## **Application by JBM Solar for the Byers Gill Solar Farm**

### **The Examining Authority's written questions and requests for information (ExQ1)**

**Issued on 30 July 2024**

Drawing Title
**Figure 7.7.1
 Visual Receptors - Before Mitigation
 Matures**

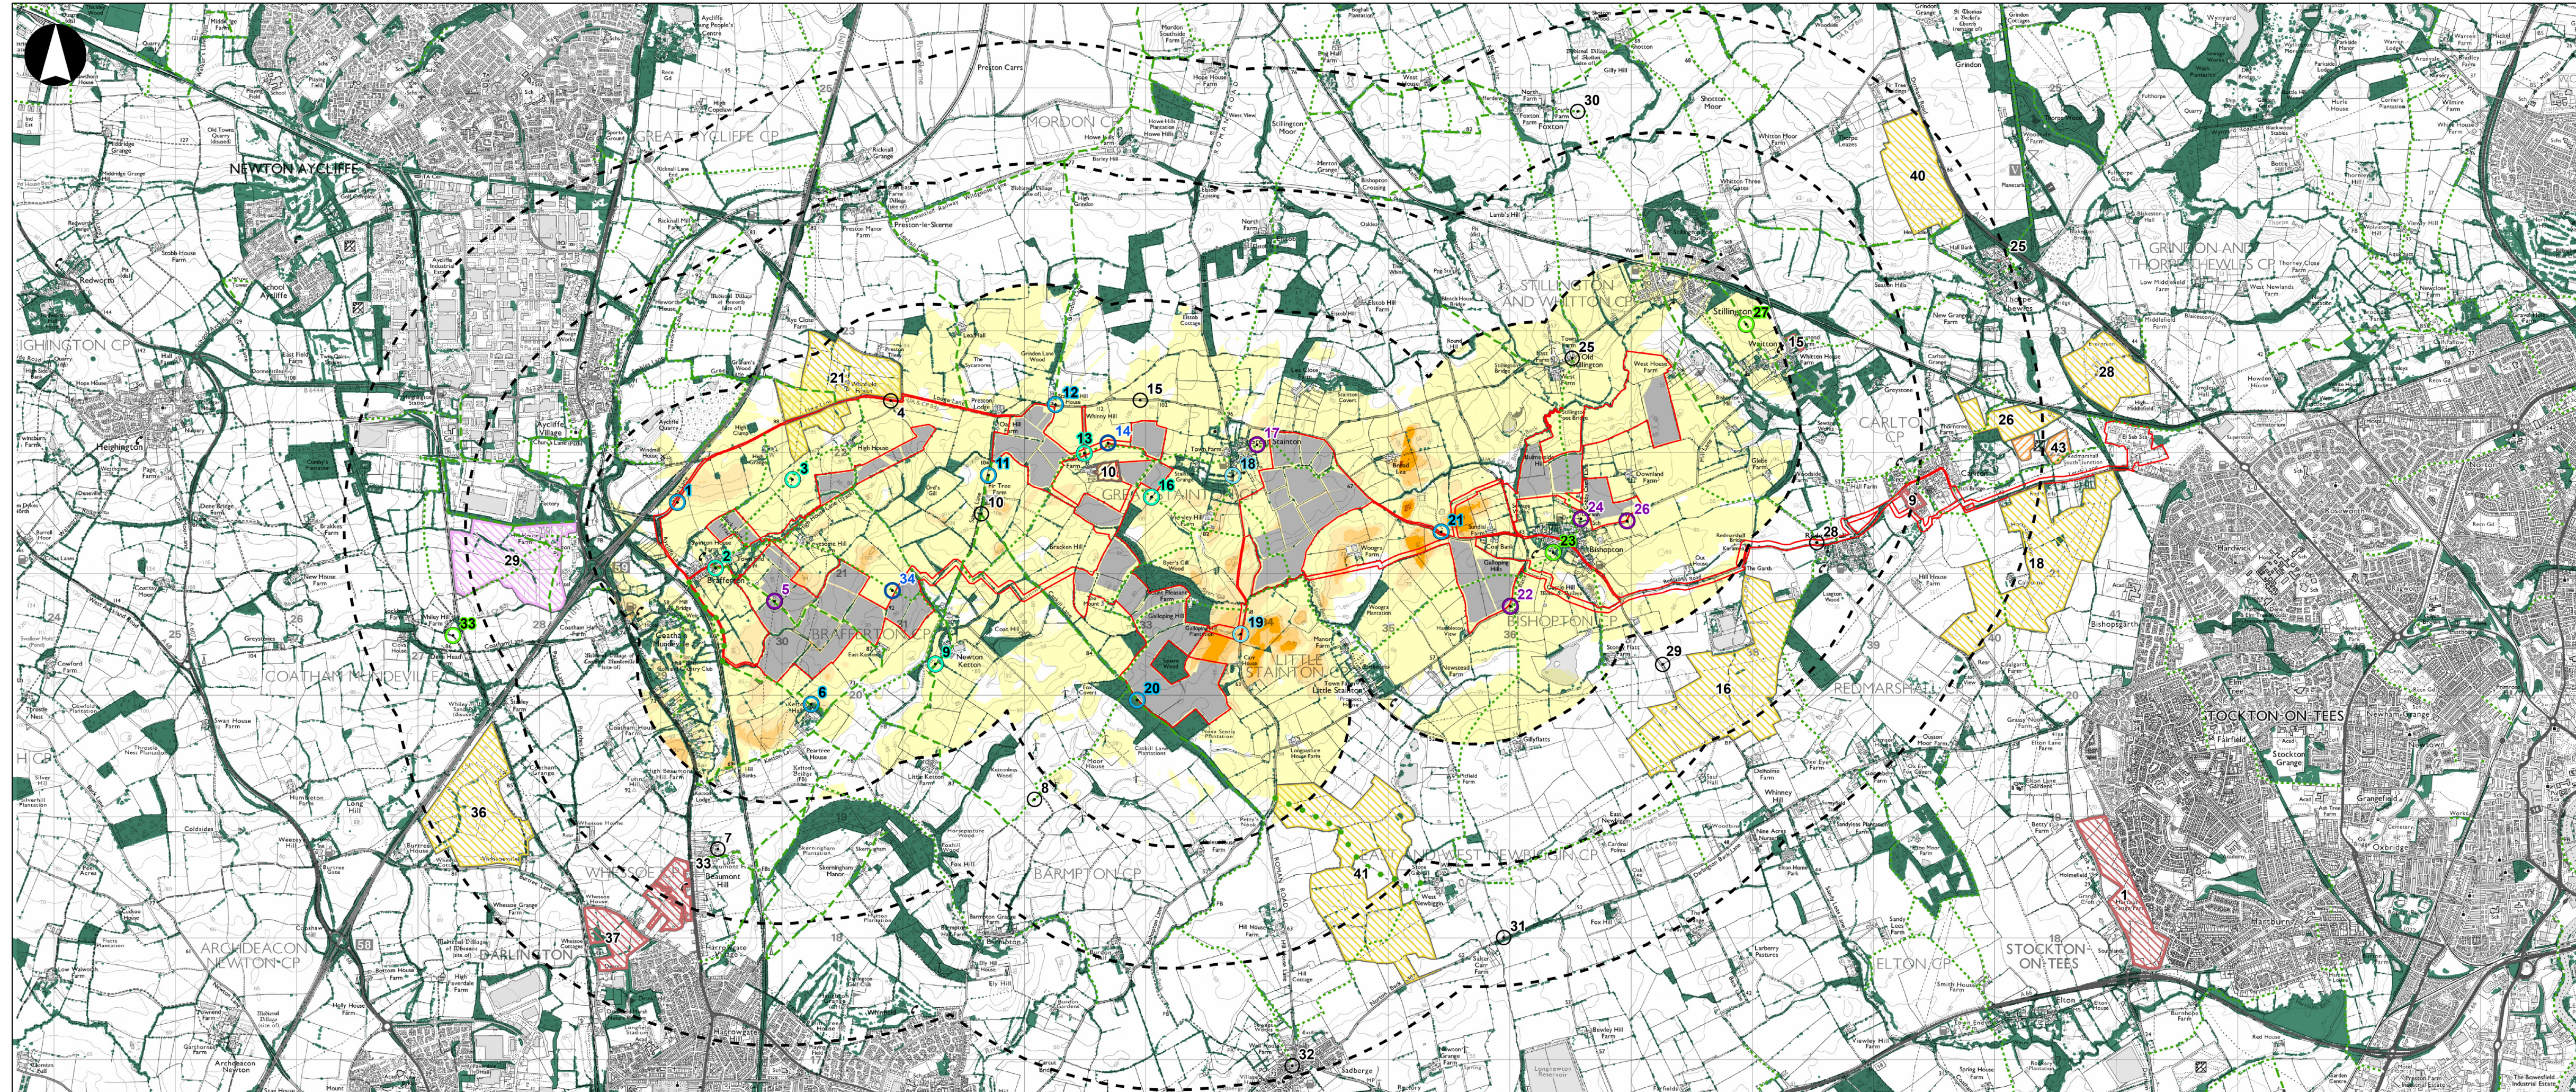
ExQ1	Question to:	Question:
		Are the relevant LPAs satisfied that the photomontages in ES Figure 7.9 have been generated using viewpoints that are representative of sensitive visual receptors?
LSV.1.3	Applicant	ES paragraph 7.4.18 [APP-030] states that the photomontages provided in ES Figure 7.9 represent Year 0 and Year 15 of the Proposed Development. However, the photomontages provided in ES Figure 7.9 [APP-071 - 074] are instead labelled to represent Year 1 and Year 10. Can the Applicant confirm which assessment years the photomontages are proposed to illustrate?
LSV.1.4	Applicant	ES Table 7-1 [APP-030] states that the photomontages provided in the PEIR have been generated using winter photography. Can the Applicant confirm whether the winter views have been used for the basis of photomontages provided in the ES?
LSV.1.5	DCC, DBC, SBC	A maximum height of 3.5m was assessed for elements of the Proposed Development within panel areas. The height of the substation and transmitter mast are set out in ES Chapter 2 [APP-025]. The substation would be no more than 8m in height and the communications mast would up to 15m (ES paragraph 2.6.18). ES Figure 7.8 [APP-078] illustrates the theoretical visibility of the substation. The Applicant concluded that views of the substation beyond the 3km study area would be limited (ES Table 7-1) [APP-030]. Are the relevant LPAs satisfied that the use of the 3.5m maximum height to assess the potential landscape and visual effects is appropriate and takes into account the worst-case scenario?
